SCOPING OPINION

Proposed Tavistock to Bere Alston railway reinstatement and associated trails

December 2014

This report sets out the Secretary of State's opinion on the basis of the information provided in the Devon County Council ('the applicant') report entitled Environmental Impact Assessment Screening and Scoping Report (October 2014) ('the Scoping Report'). The Opinion can only reflect the proposals as currently described by the applicant.

**Figure 14. Minerals consultation areas surrounding the project**

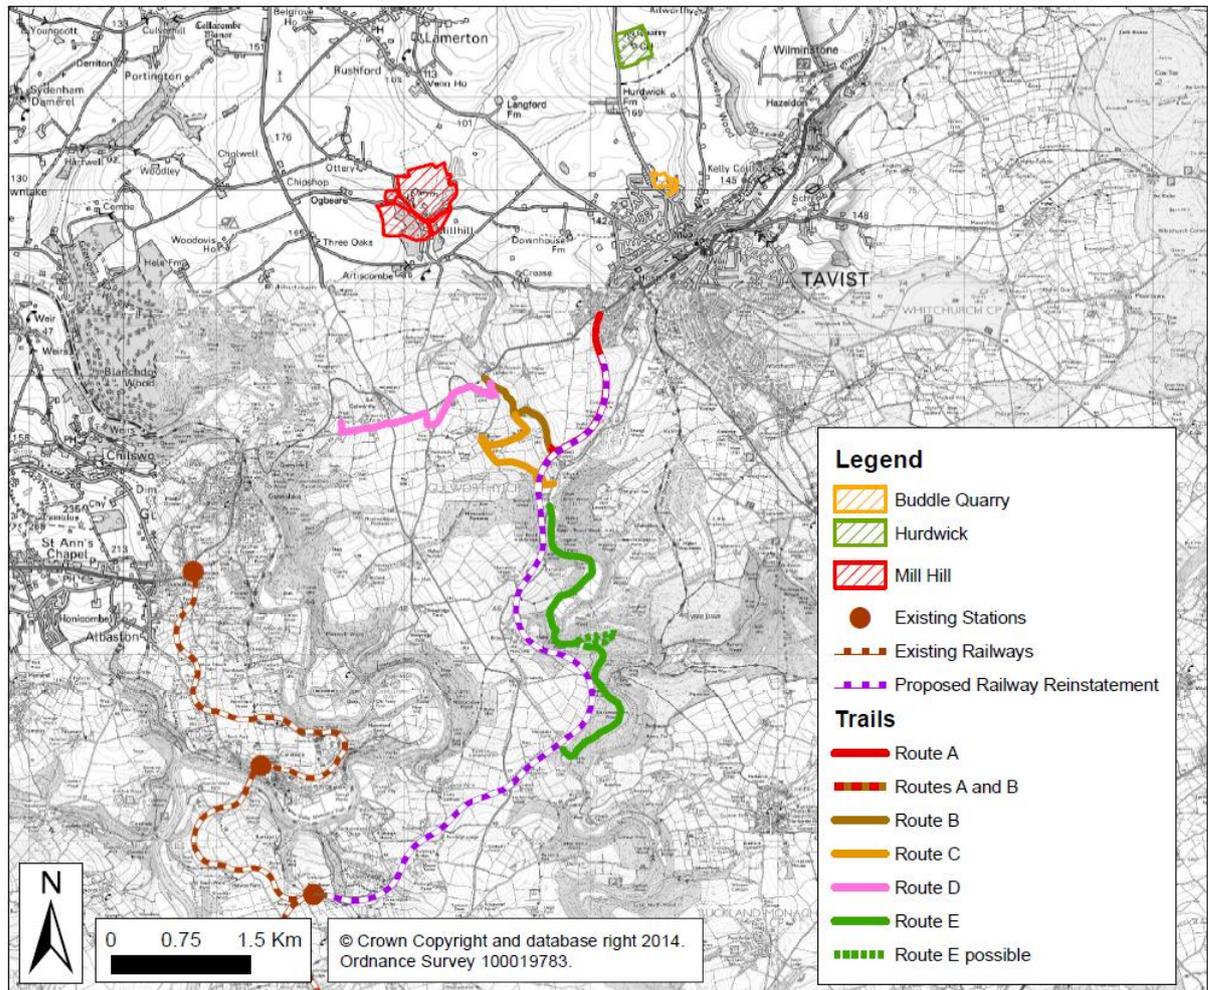
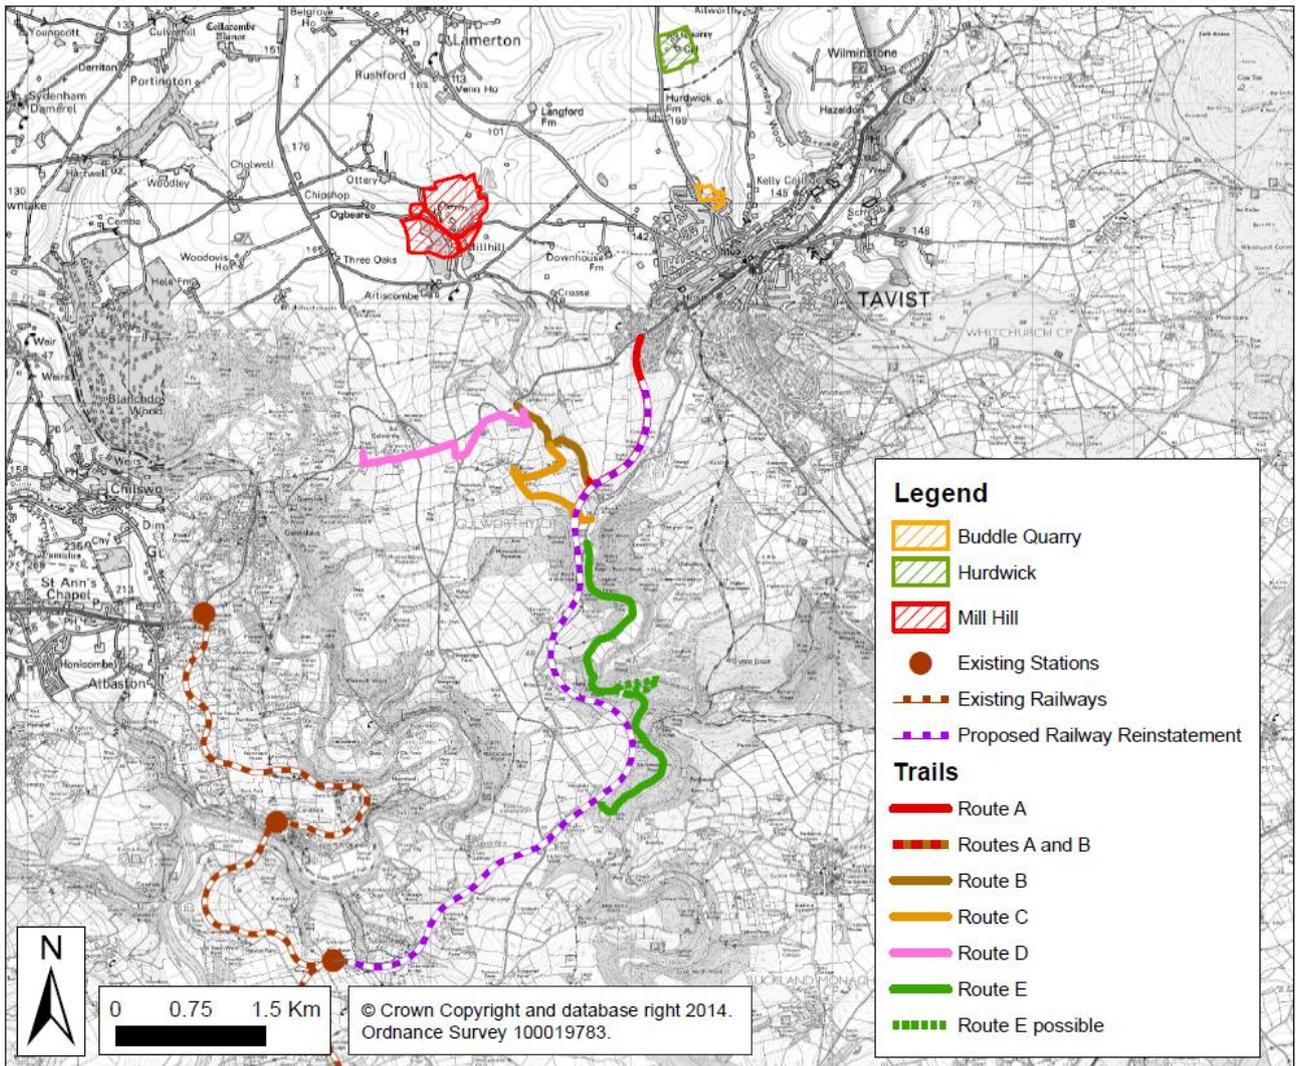
- Impacts on minerals as a resource. The ES should however provide evidence to support the statement in Paragraph 10.3.2 of the Scoping Report that previous mining uses within the site have long ceased.
- Air quality impacts from the operation of the trails.
- Nitrogen levels beyond 200m of the proposed development. This is provided the ES demonstrates how the approach complies with best practice guidance such as the Design Manual for Roads and Bridges. All other potential impacts on air quality (including those identified in Paragraph 12.4.1 of the Scoping Report) should still be assessed.
- The potential for increased human activities and their associated health benefits. This does not preclude the

Figure 15. Agricultural Land classification

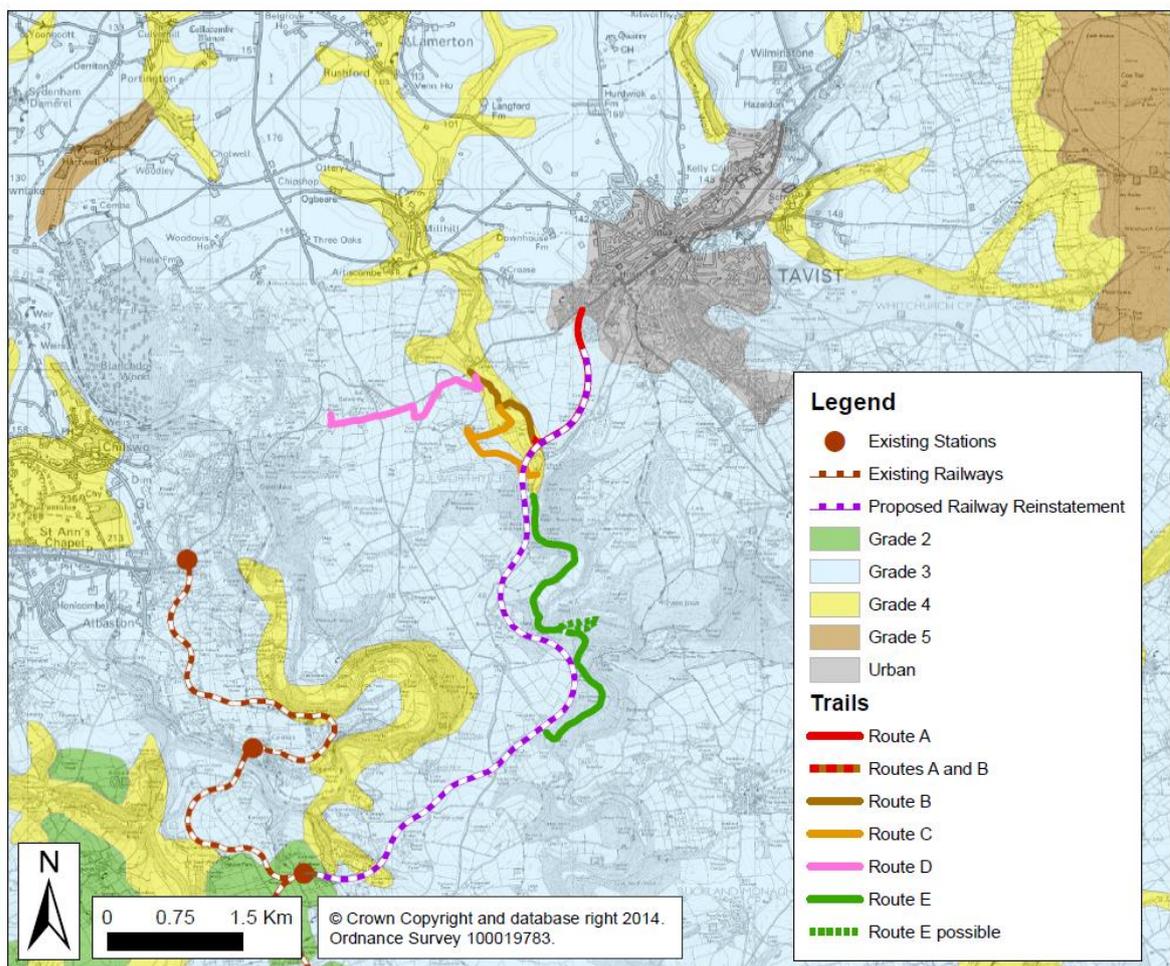
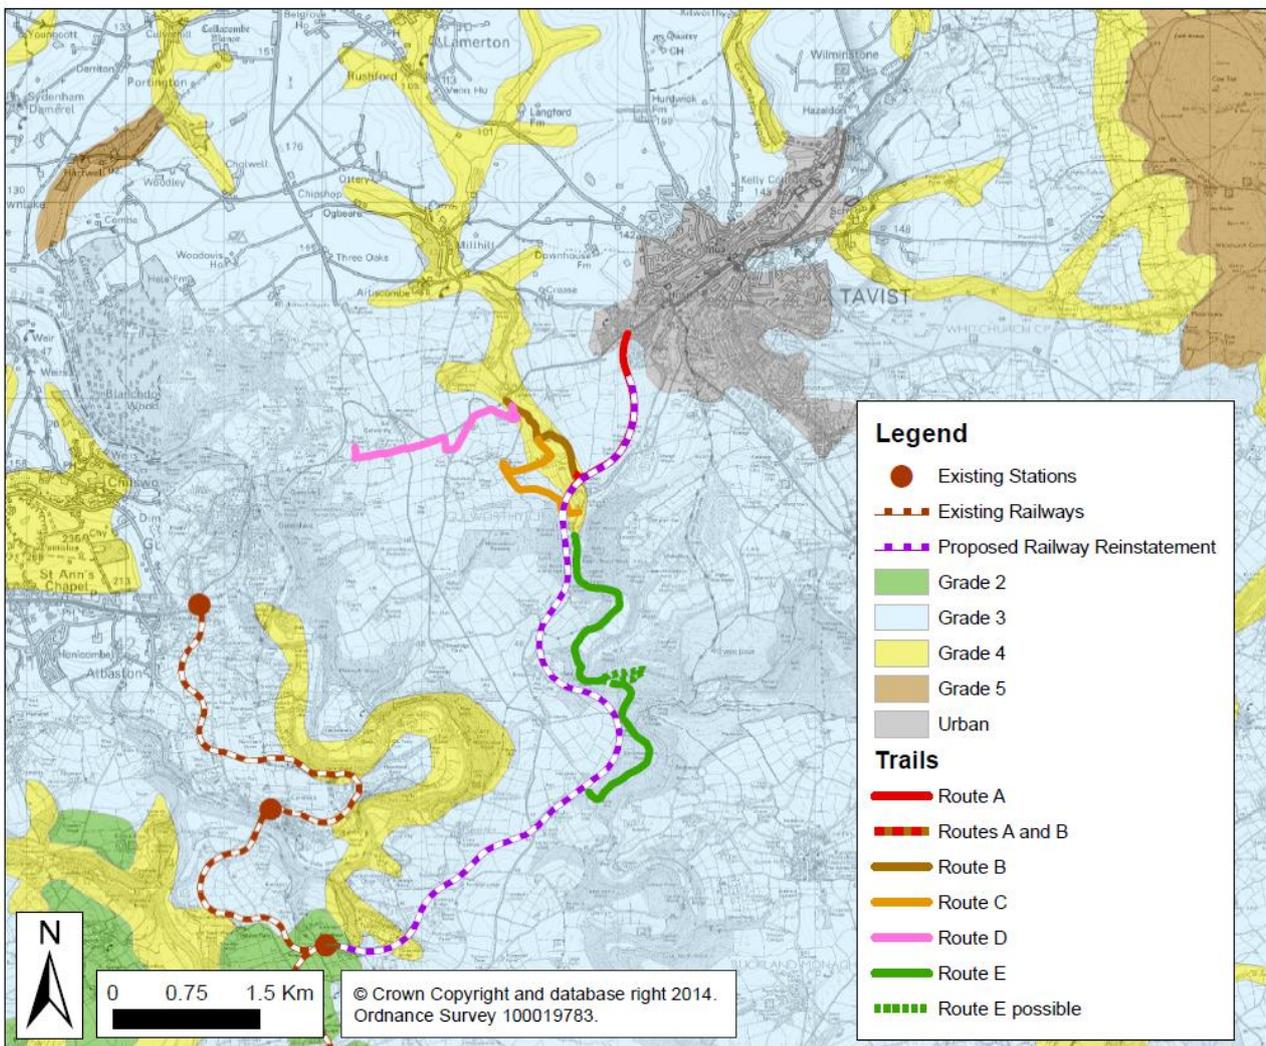
- 2.43 Chapter 10 of the Scoping Report indicates that parts of the proposal would be located on agricultural land. The ES should describe the amount and classification of agricultural land which would be lost as a result of the proposed development. The relationship between this land and its associated agricultural unit should also be described (to determine the potential for severance impacts).

- **Impacts on agricultural land:** the justification to scope impacts on agricultural land is confusing and does not provide sufficient certainty that potential effects would not be significant. Paragraphs 10.3.7 – 10.3.9 of the Scoping Report seek to explain why impacts would be minimal and would not be assessed, however the last of these paragraphs also states that there may be social/economic impacts of losing small areas of farmland and that these would be assessed. The area of agricultural land that would be lost is also not clear at this stage and the Report does not address the potential for significant effects that could arise from the mobilisation of contaminants onto agricultural land or from access, severance, or disturbance/disruption issues threatening the operation or viability of farming units.
